Rezoning Transportation Analysis
Petition Number: Insert Zoning Petition #2021-195
General Location Identifier: 20105108, 20105106

Revision Log:

Date	Description
12-28-2021	First Review (PDM)
01-27-2022	Second Review (KP)

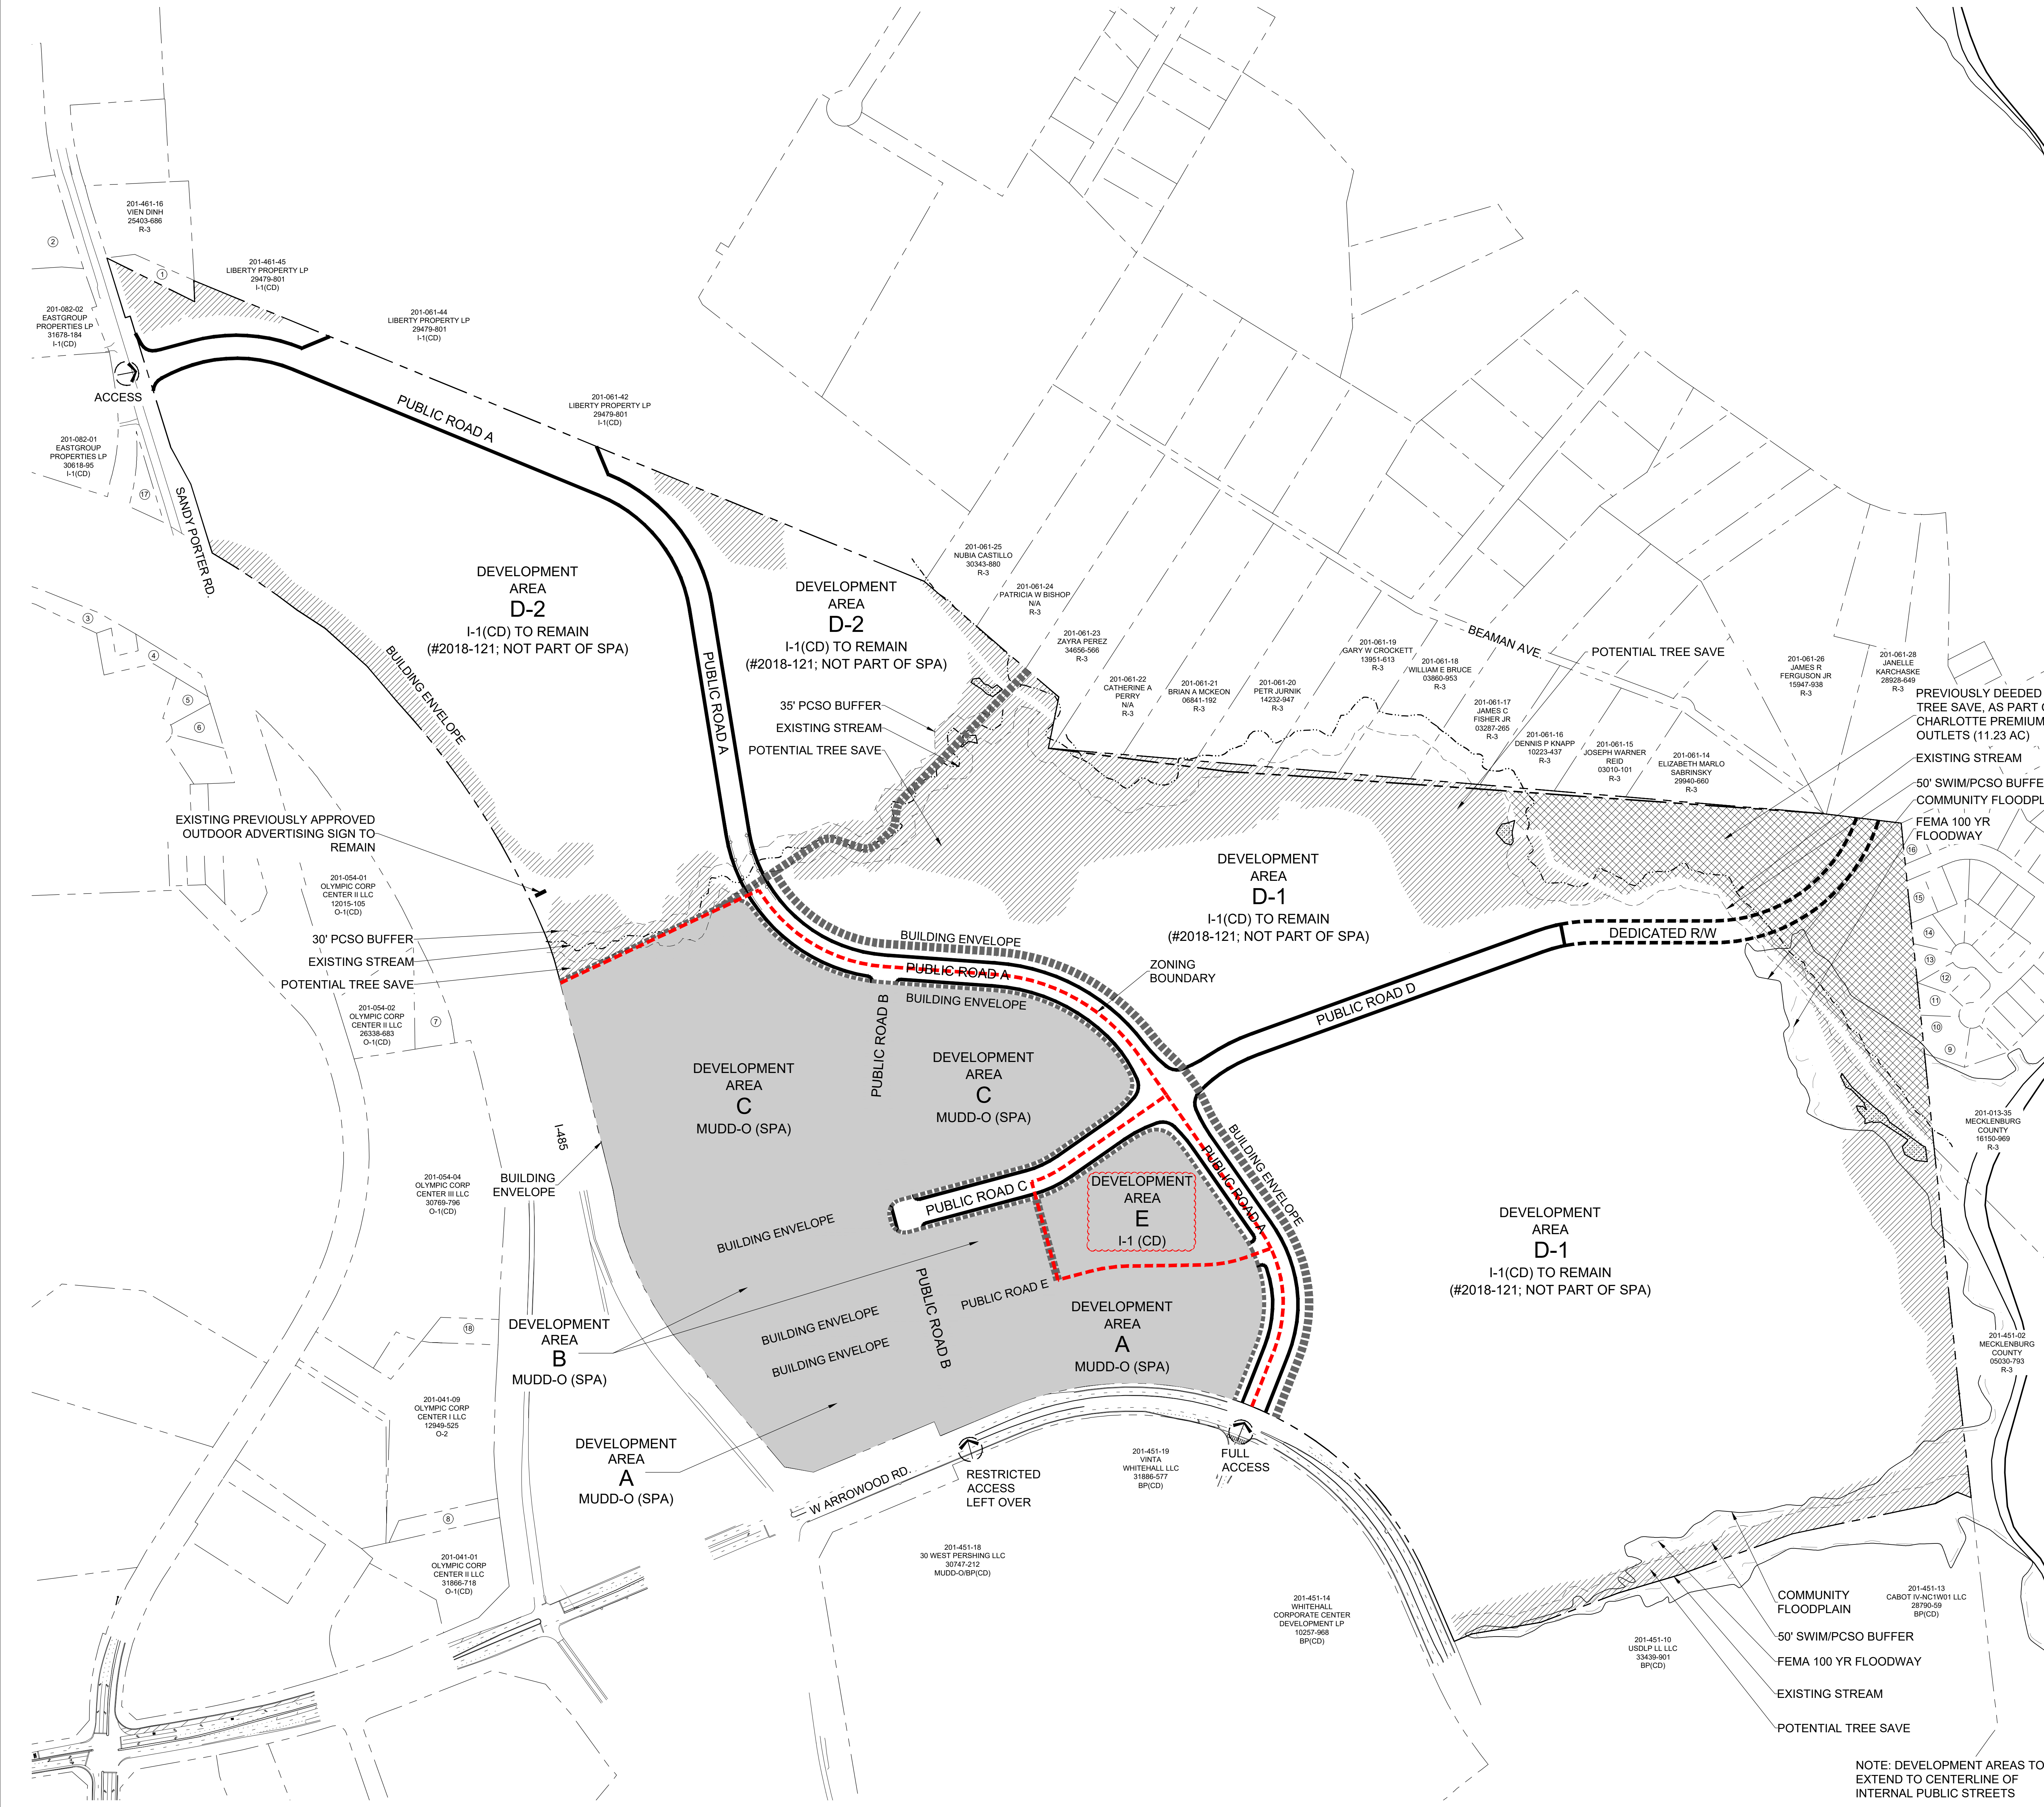
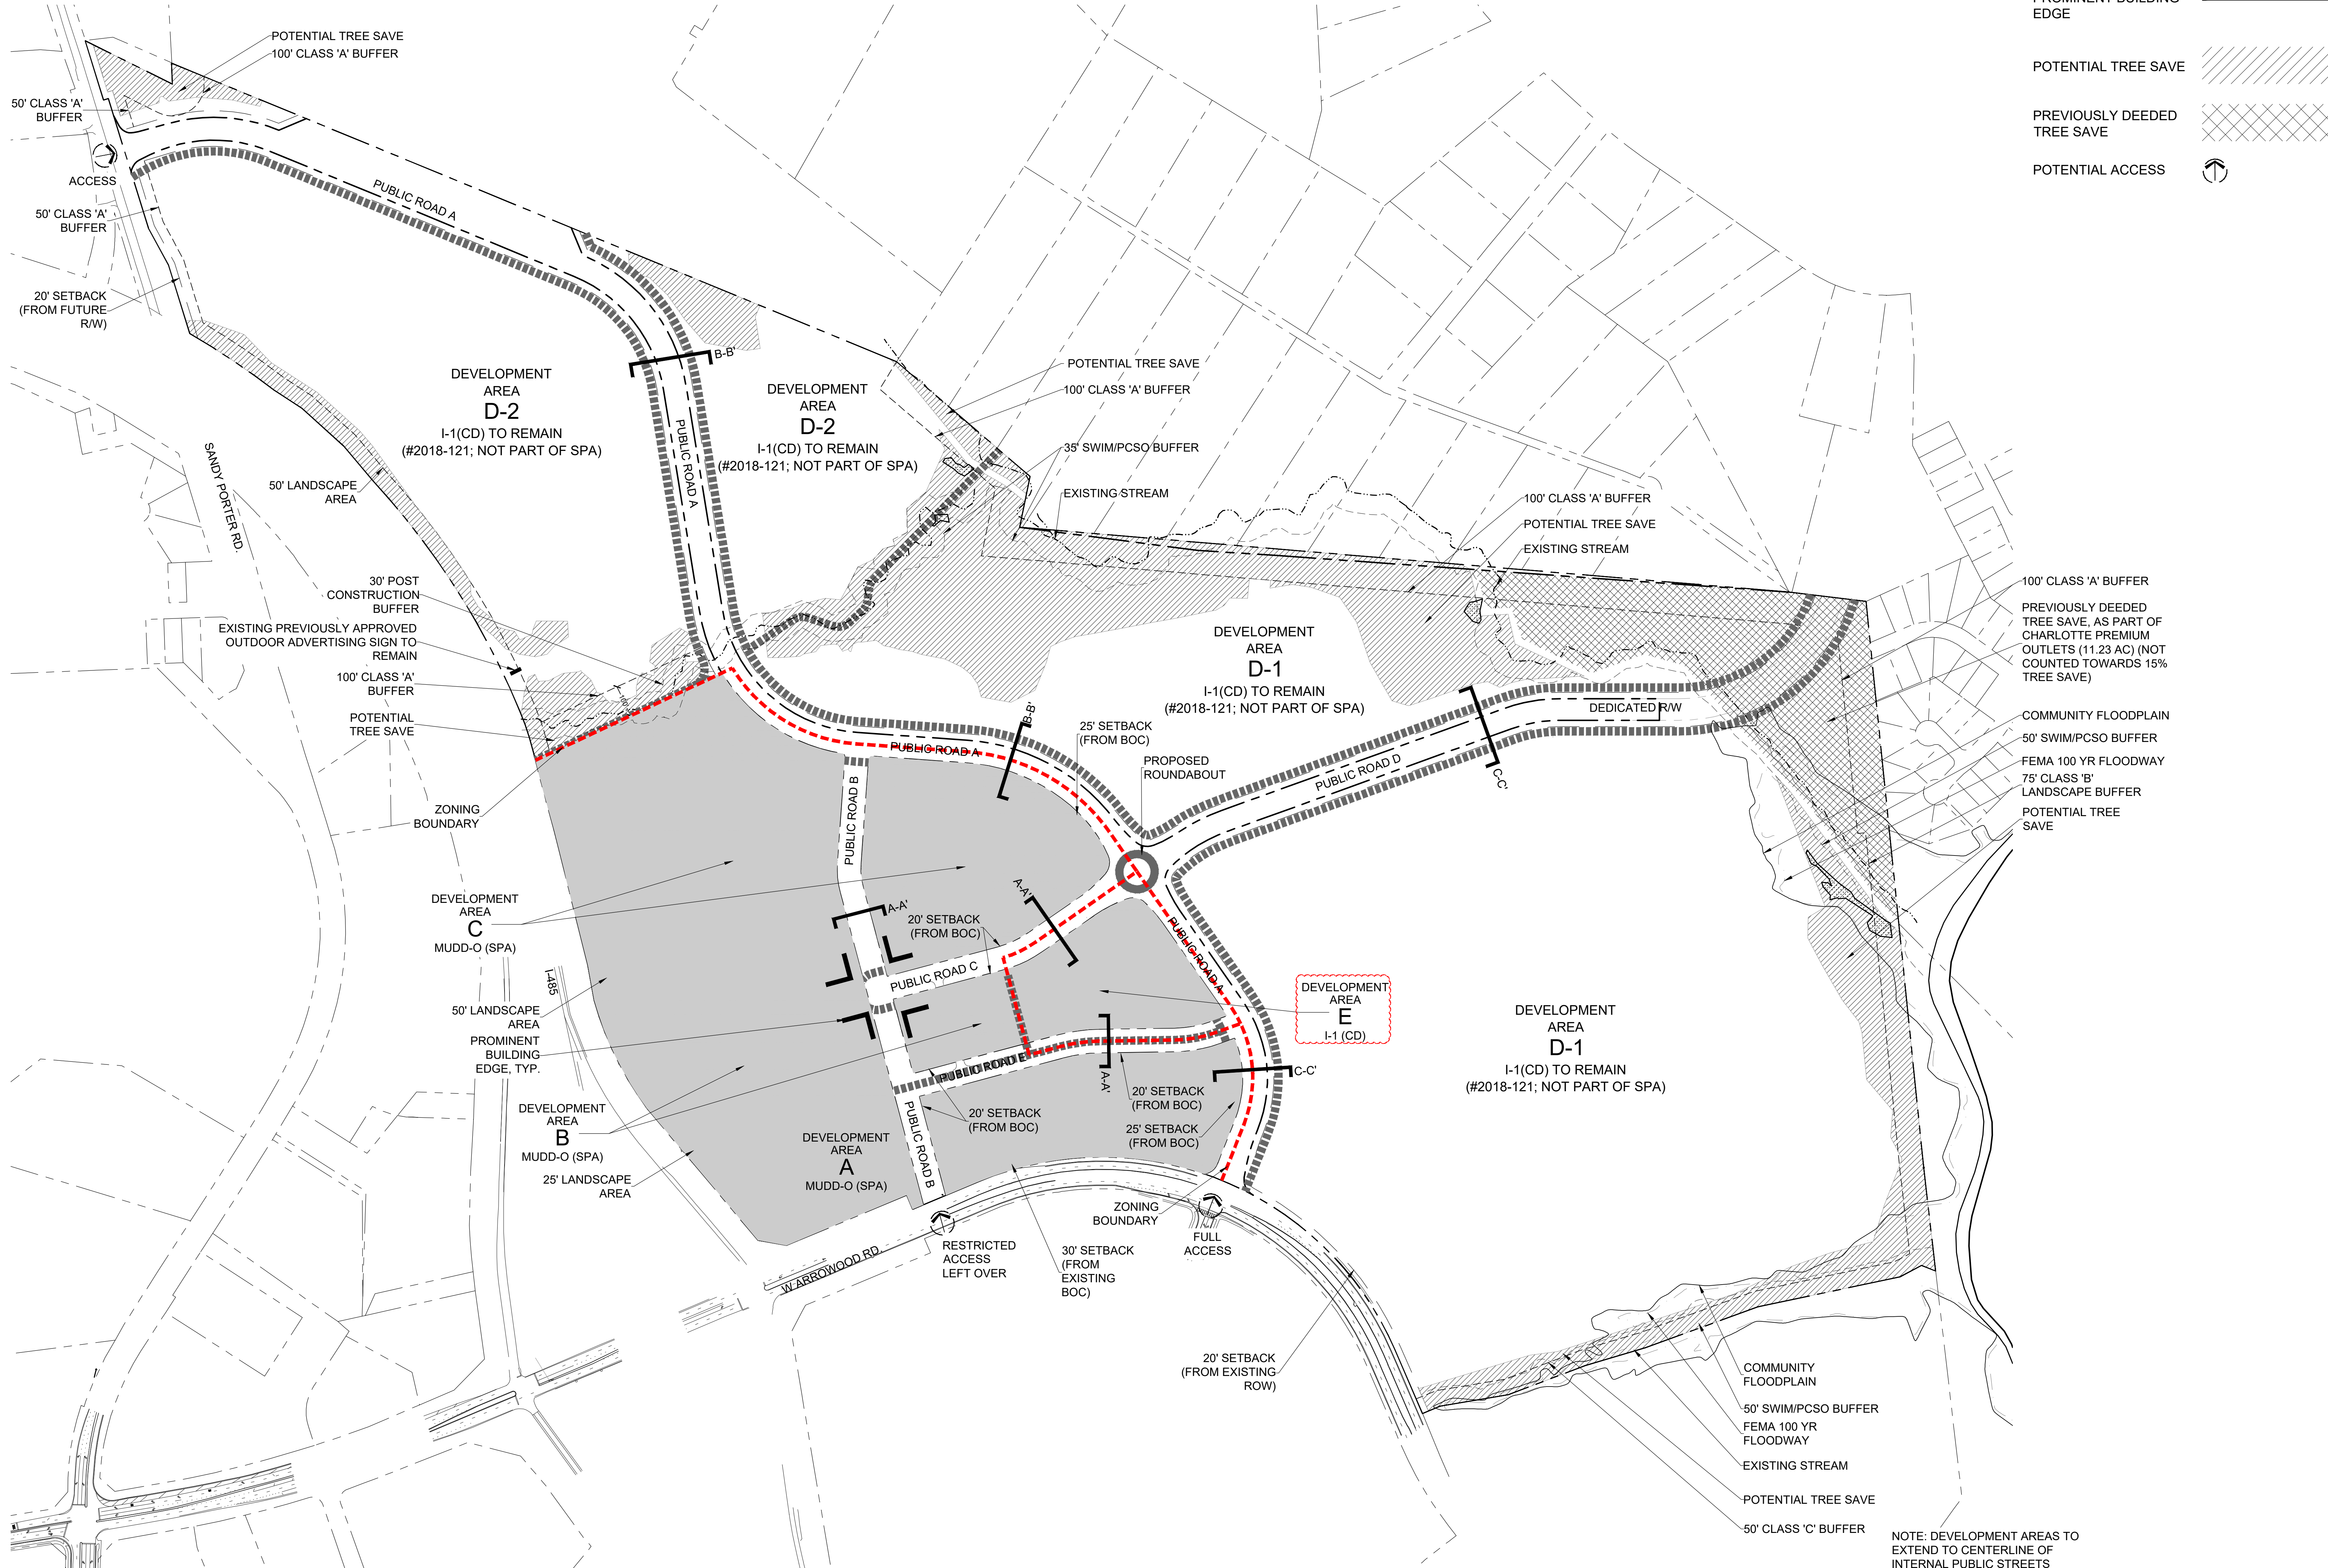
1. **Outstanding Comment from 12-28-2021: Curb line:** The proposed zoning district has a setback measured from back of the existing or proposed future curb line.
 - a. **Arrowwood Road:** The future location of curb and gutter is in the existing location

Label and dimension the curb and gutter from the centerline for each road on the site plan.

3. **Outstanding Comment from 12-28-2021:** Revise site plan and conditional note(s) to commit to construct an 8-foot planting strip, and 12-foot sidewalk on the entire property frontage of Arrowwood Road per Chapter 19 and Chapter 20. The site plan shall label and dimension both items from the back of curb and gutter and road centerline. The 12ft multi-use path also meets the council adopted Charlotte WALKS and Charlotte BIKES policies.

4. **Outstanding Comment from 12-28-2021:** Revise site plan and conditional note(s) to commit to constructing an 8-foot planting strip and 12-foot multi-use path along Sandy Porter Road per the pervious approved rezoning. The previous note show below should be used.

5. **Outstanding Comment from 12-28-2021:** Revise site plan and conditional note(s) to restrict Public Road E access at Public Road A to right-in / right-out if the required minimum intersection sight distance cannot be achieved.

6. **Outstanding Comment from 12-28-2021:** Add conditional note committing to the dedication of right-of-way to allow for the extension of Public Road D to the property line.

9. **New Comment from 01-17-2022 Site Plan:** Remove conditional notes 4.II.e and 4.II.f
